Recommendation Report for Planning Permission for Works or Extension to a Dwelling

REF NO: FP/9/26/HH

LOCATION: 4 Davenport Road
Felpham
PO22 7JP

PROPOSAL: Garage conversion and external and internal alterations to existing dwelling.

DRAWING No
462/04

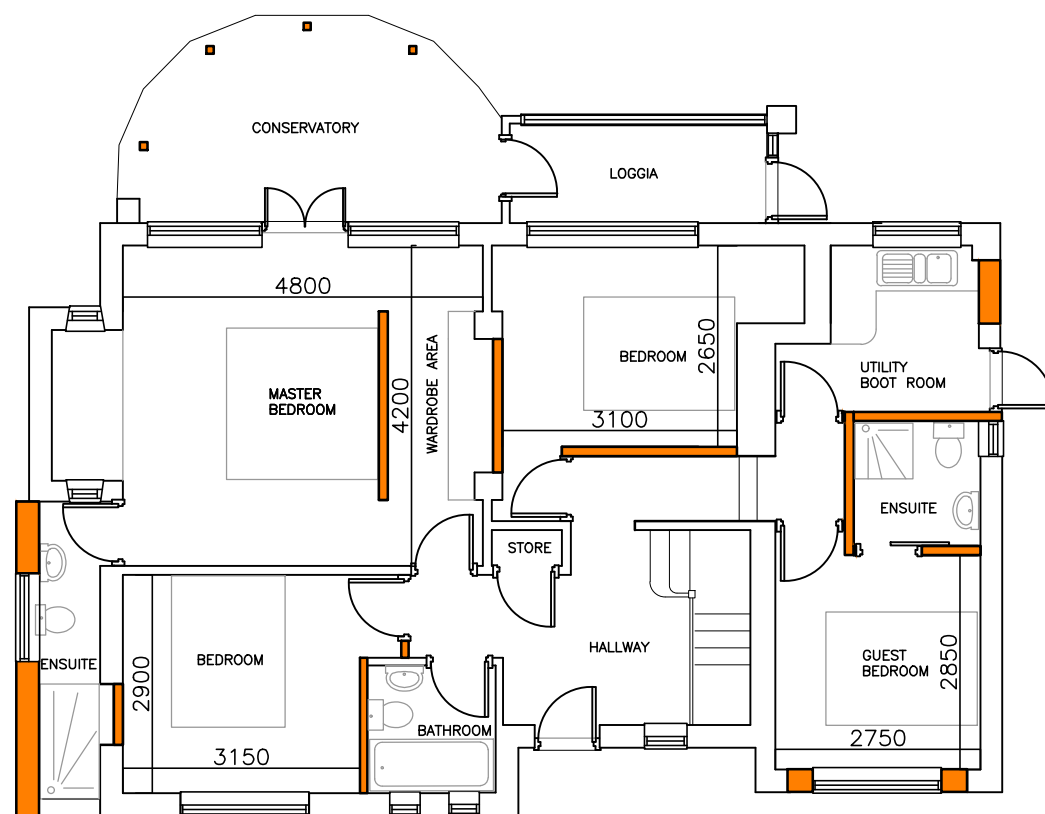
This application is accompanied by a Flood Risk Statement which outlines that the ground floor of the garage conversion would be constructed in line with the existing floor levels of the host dwelling, given the potential of flooding. A condition is attached to this planning permission to require the garage conversion to be carried out in accordance with these details, in the interests of flood risk.

- 3 The internal floor level of the garage conversion hereby permitted shall be constructed no lower than the existing internal floor level of the host dwelling.

DRAWING
**PROPOSED
ELEVATIONS**
DRAWING No
462/05
REVISION
SCALE 1:100
DATE DEC 2025
DRAWN LA
CHECKED

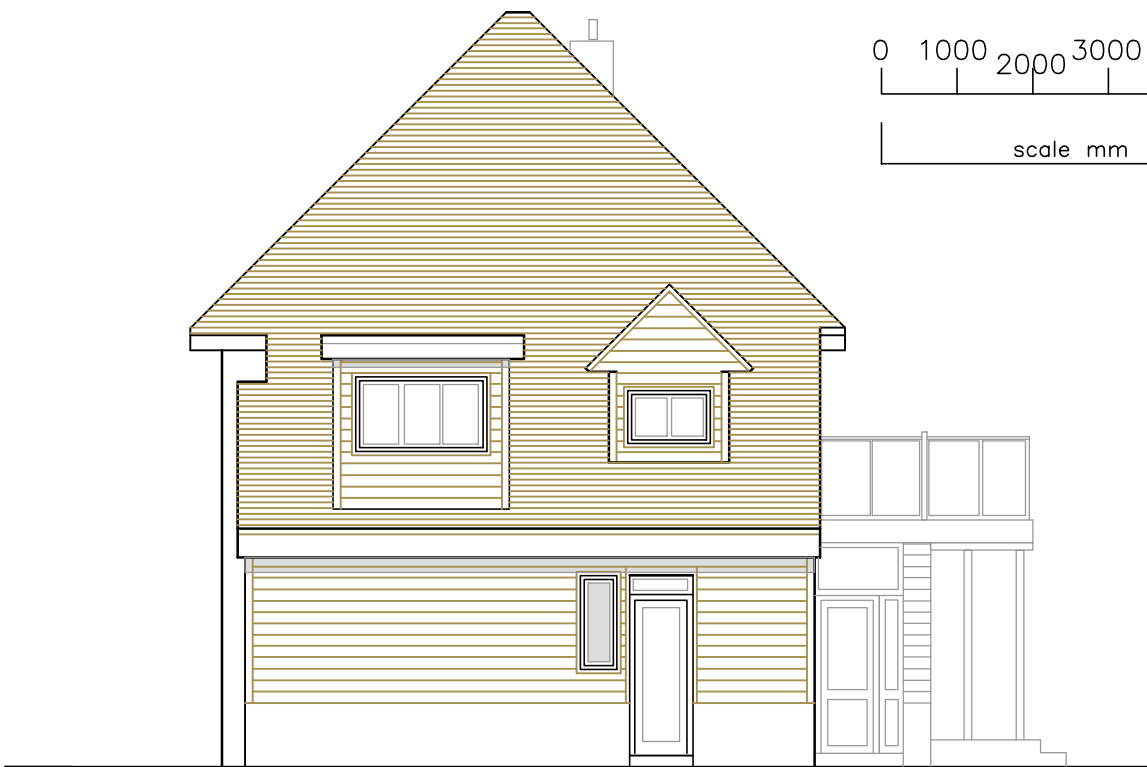
To the south (rear) elevation, it is proposed to replace the existing conservatory windows with full length glazing, wrapping around to the sides of the conservatory and loggia respectively. Internally, the two doors (both with full large windows either side) would be removed; sliding doors and a new window would be installed. At first floor level, a new balcony design would be implemented, with fewer balustrades, giving a less cluttered appearance. Sliding doors and a new window would replace the three existing windows that currently serve the first floor accommodation, a continuation of a glazed, more simple appearance that would be introduced at ground floor level.

The western flank elevation is separated from the western flank of 6 Davenport by 0.9m. Amendments to the western elevation are isolated to the ground floor only, with a new window replacing the existing doors and window.

The only amendment proposed to the front elevation would be replacing the garage doors with a window, to accommodate the proposed garage conversion to habitable space. Amendments to the eastern flank elevation would also be isolated to the ground floor. A new door and window, set further back from the rear elevation than the existing door and window proposed for removal, would provide serve the ground floor accommodation.

Windows and doors are proposed to be white UPVC, rather than the existing brown UPVC. Painted render and horizontal weatherboarding are proposed as external finishes. Davenport Road has a varied material palette; brickwork, render and tiling are all commonplace. The render and weatherboarding proposed would contribute to the varied street scene and would not result in harm to the character or appearance of the area, in accordance with Arun Local Plan policies D DM1 and D DM4.
